From: Simon Davis
Sent: 11 June 2019 12:29
To: Planning.Responses
Cc: Conservation Officer
Subject: FW: FP/57/19/PL - The Malthouse Restaurant, Waterloo Road, Felpham
Attachments: Heritage Statement Rev 1.pdf

From: stewart morris [REDACTED]
Sent: 29 May 2019 08:43
To: Simon Davis [REDACTED]
Subject: FP/57/19/PL - The Malthouse Restaurant, Waterloo Road, Felpham

DRAWING TITLE:
Proposed Floor Plans

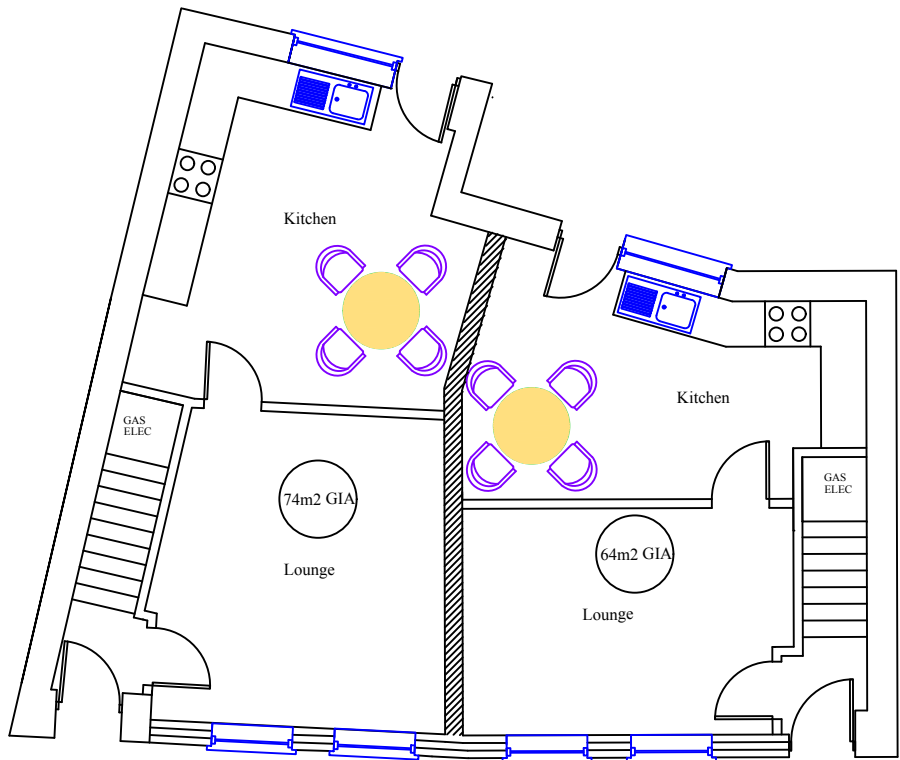
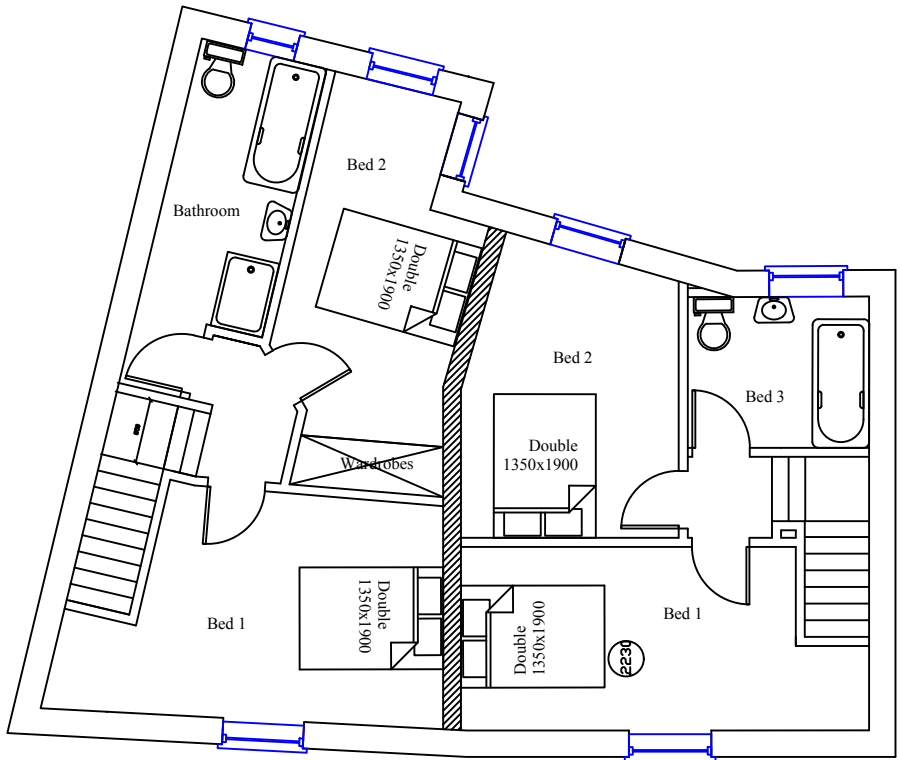
I also have a slight concern regarding space standards in that both flats are shown as having 2 double bedrooms but one of them is only 64m² in area. The required standard for a 2 bedroom, 4 person dwelling is 70m². However, can you confirm the actual size of the bedrooms as it may be the case that if a bedroom is less than 11.5m² in area then for the purposes of the standards it is treated as a single. Two bedroom, 3 person dwellings require only 61m².

I can confirm that the rear bedroom of the 64m2 cottage is 11.0m2 and would therefore request that you consider this cottage to be a 3 person dwelling, all as your email.
